Demolition of existing building & erection of 1 No. retail unit & 3 No. flats above with associated external works & access. This application may affect the setting of Listed Buildings & the character & appearance of the Littlehampton (River Road) Conservation Area.

Littlehampton Covered Market 26-28 Surrey Street Littlehampton

Thank you for your internet comments made on 10th January 2018 which has been recorded as **'no objection'** with the comments as follows:

GROUND PLAN

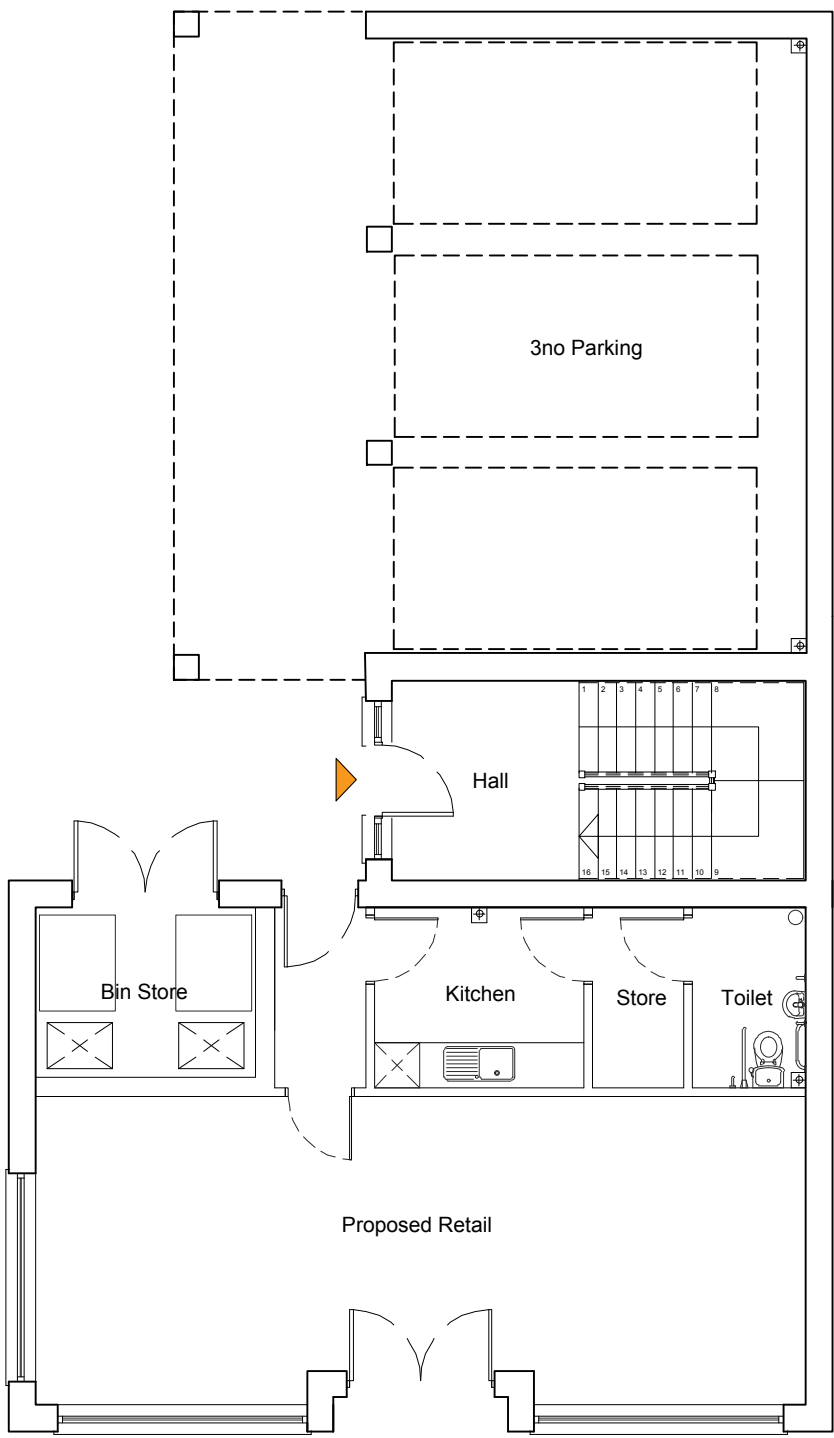
The Town Council's Planning and Transportation Committee considered this matter at its meeting held on Monday 8th January and had no objection to the application. Members questioned whether the planned layout of the ground floor was suitable for the envisaged retail use as it appeared limiting. Observing that vehicle access to Surrey Street would be across a pavement, the Committee had no objection to the proposals subject to the comments from West Sussex Highways as the Highways Authority.
